From: Brenda Larsen
Sent: Friday, March 27, 2015 12:41 PM
To: Michael Flory; Jeff Watson
Subject: McIntosh CU-14-00004
Attachments: McIntosh.doc

Re: McIntosh (CU-14-00004)

Upon review of the above mentioned land use action, I have the following comments/requirements;

EXISTING
OUTDOOR ARENA

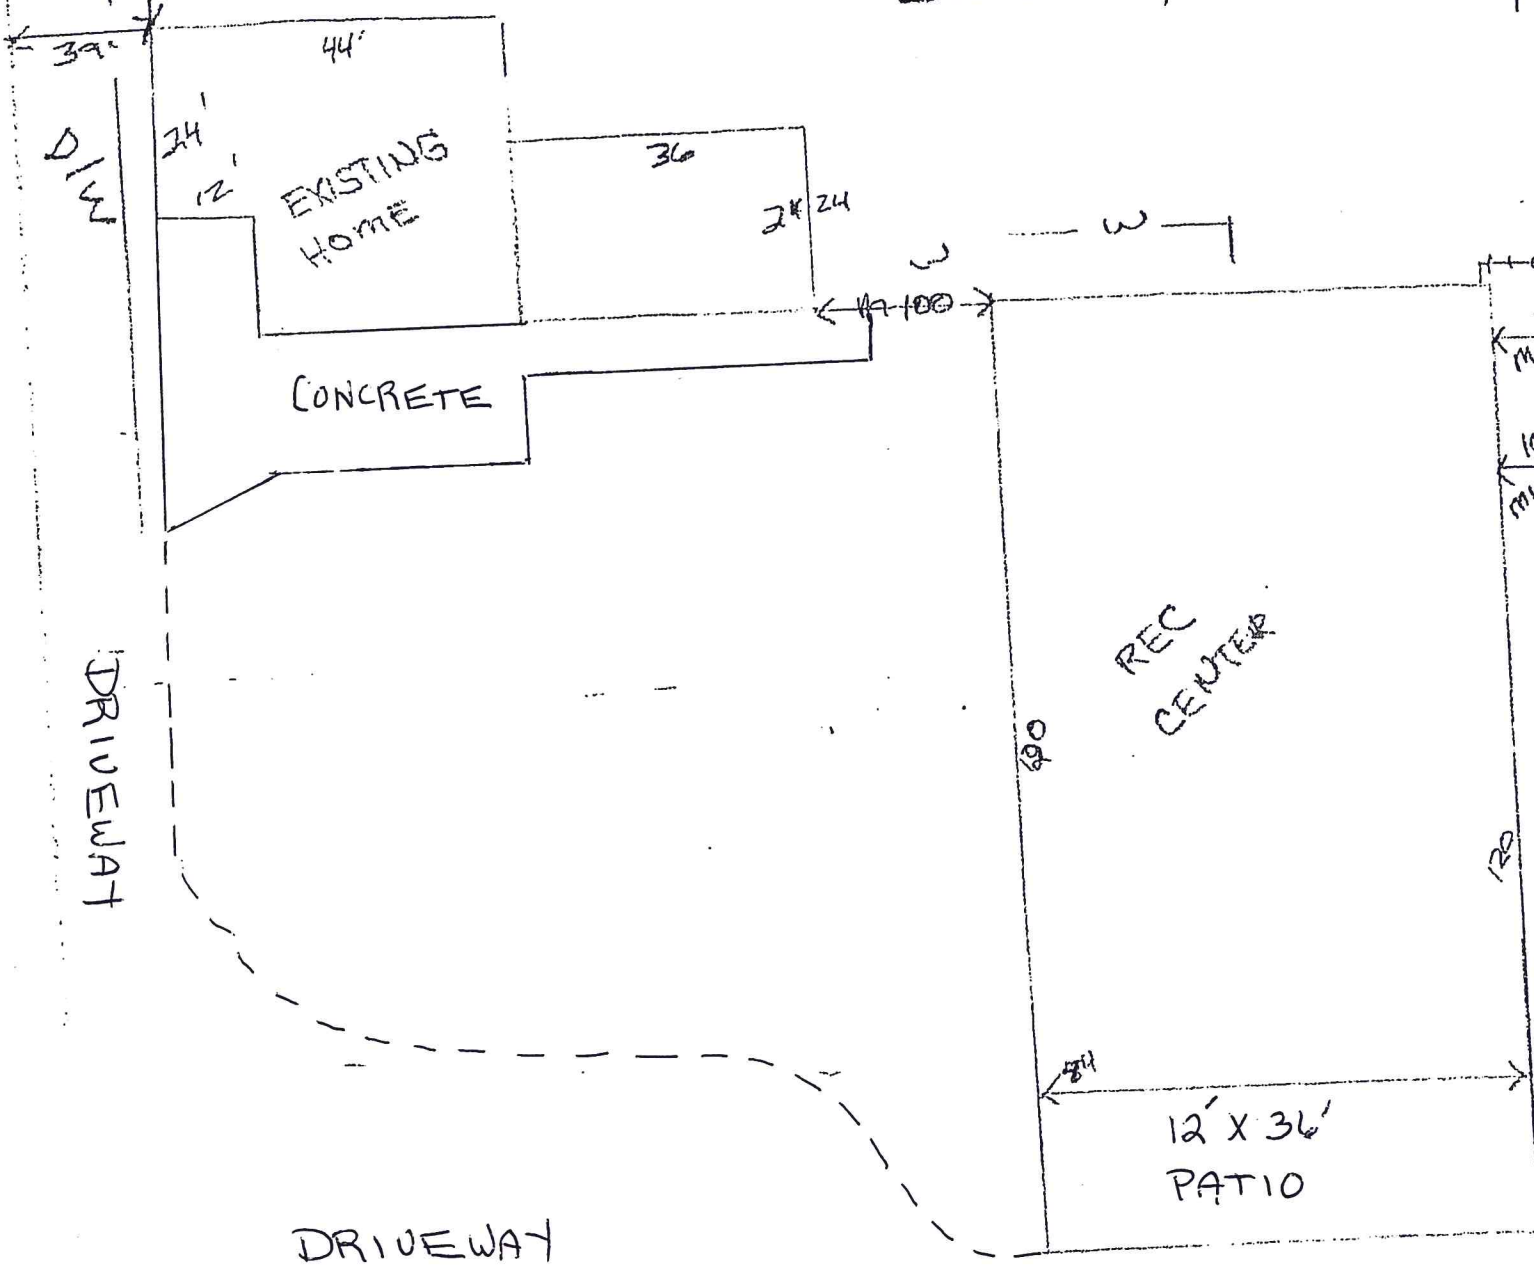
- A turn-around shall be provided for fire department access.
- It would be best for any trailer traffic to park in the very back parking lot, with signage indicating parking for trucks/trailers.

- Passenger vehicle parking must be regulated so that emergency vehicles have full access throughout the facility. Signage and/or staffing for events should be provided so that people do not mistakenly park in a fire apparatus access lane.
